**OXFORDSHIRE COUNTY COUNCIL’S RESPONSE TO CONSULTATION
ON THE FOLLOWING DEVELOPMENT PROPOSAL**

Application no: 22/02647/F

Proposal: Planning Application for Development within Use Classes E (g) (i), and/or (ii), and/or (iii), and/or B2 and/or B8 and Associated Works including Access and Parking

Location: Unit 8 4B, Oxford Technology Park, Technology Drive, Kidlington, OX5 1GN

content: BUILDING 6
PROPOSED CYCLE LOCATIONS
date: JUNE 2022

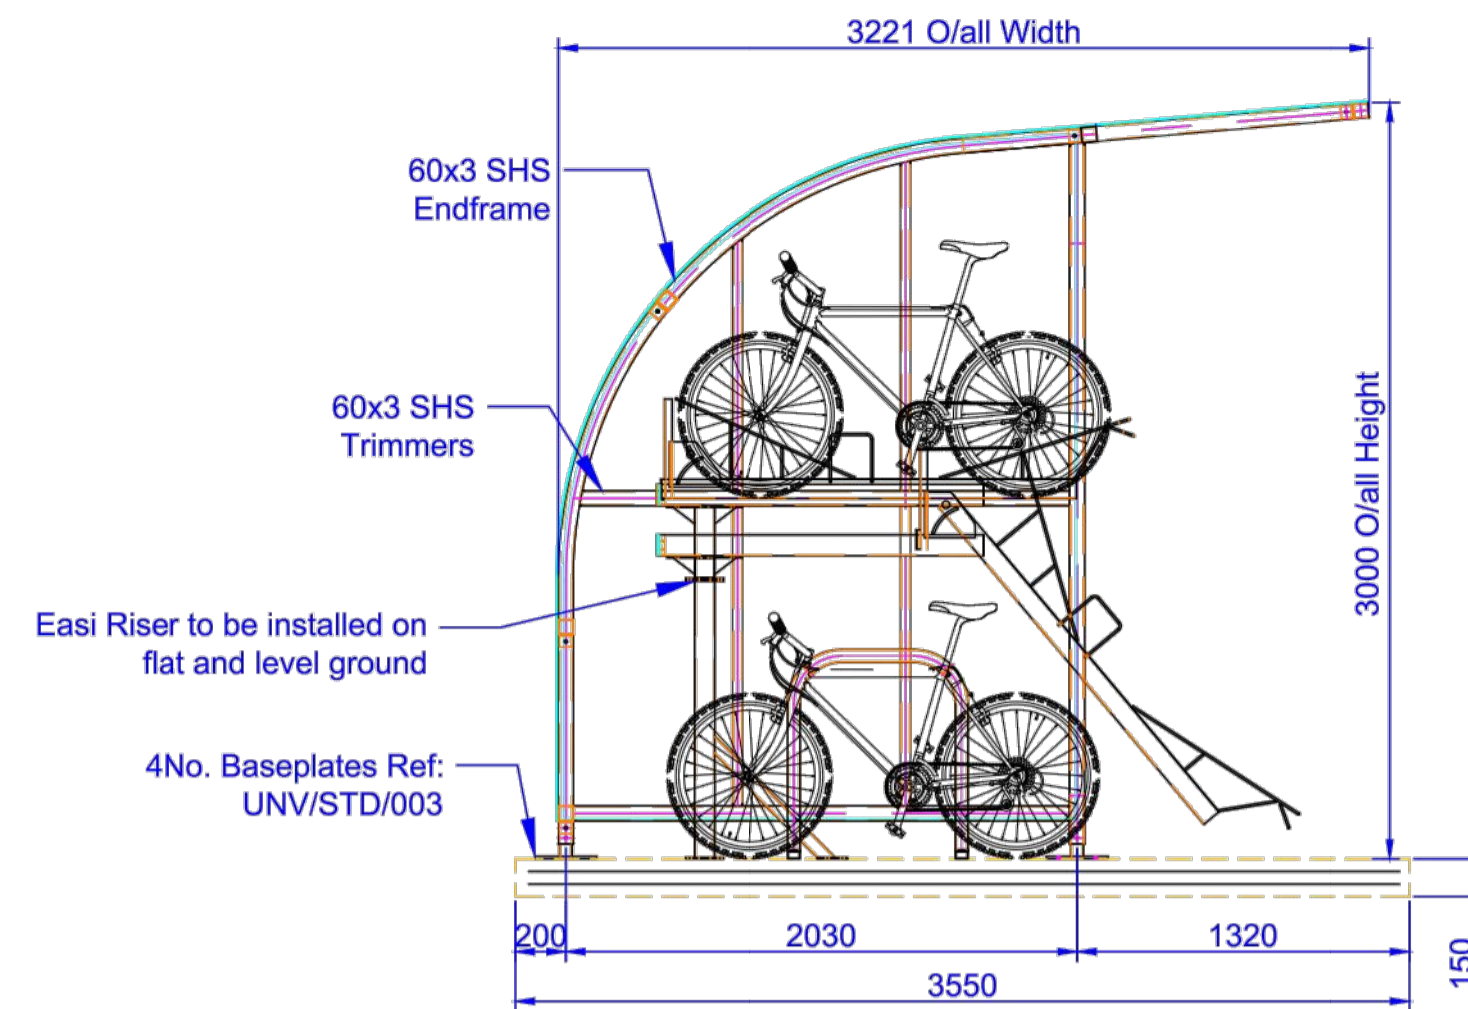
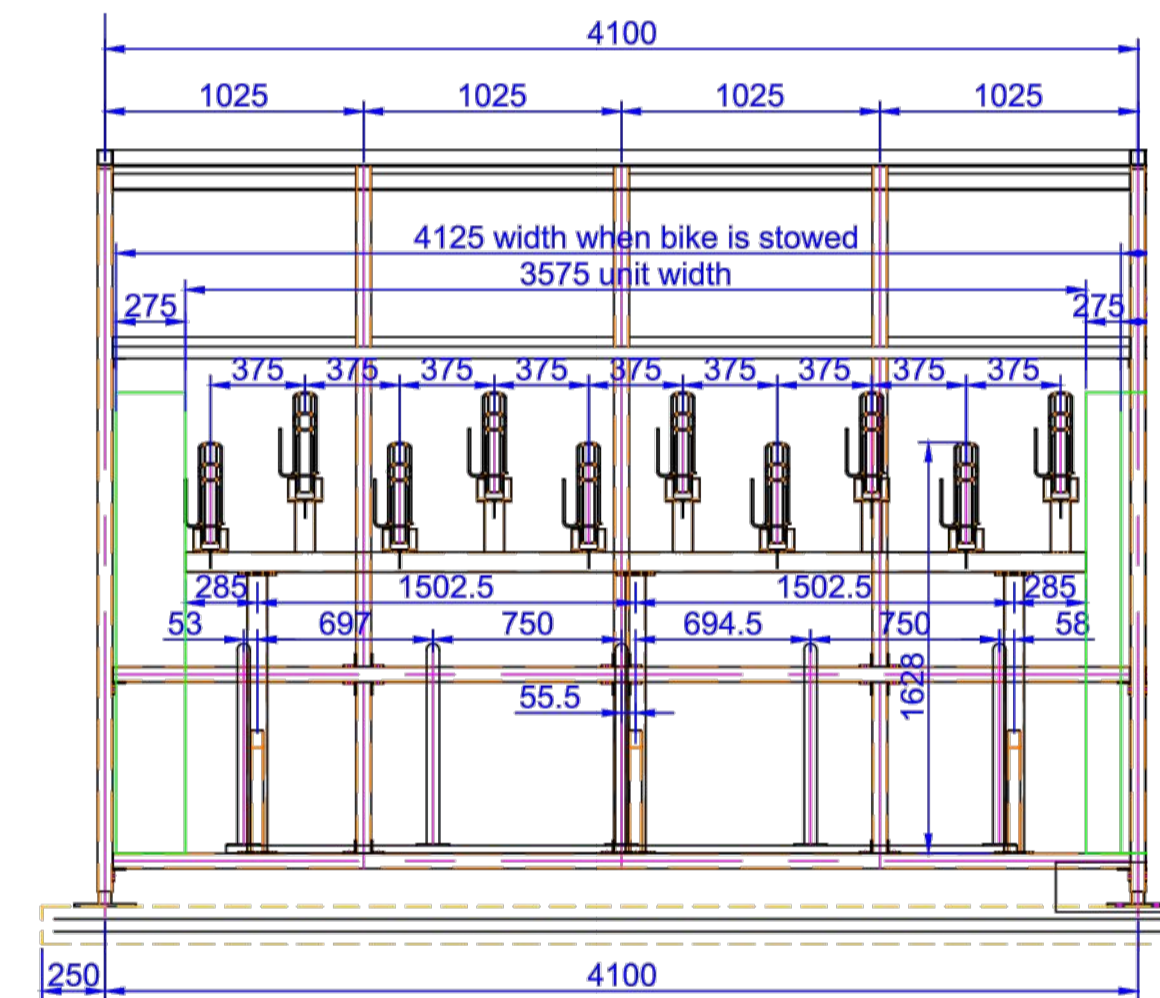
- The provision for Electric Vehicle charging is below minimum standards set out in the Oxfordshire Electric Vehicle Infrastructure Strategy and OCC's adopted Parking Standards. Provision for 25% of all parking spaces is required.
- The use of double-stacked cycle parking is inappropriate in this instance and, in accordance with OCC's adopted Parking Standards and LTN 1/20, easily accessible cycle parking that is level with the street is required.

The provision of 40 covered and secure cycle parking spaces is in line with the required standards. However, the adopted OCC Parking Standards set out that double decked cycle parking should not be used as they are difficult to use and not all people are able to use the upper rack, and that Sheffield stands should be used. The layout and spacing of stands should be as per LTN 1/20. I therefore consider that the provision for covered cycle parking should also be reviewed.
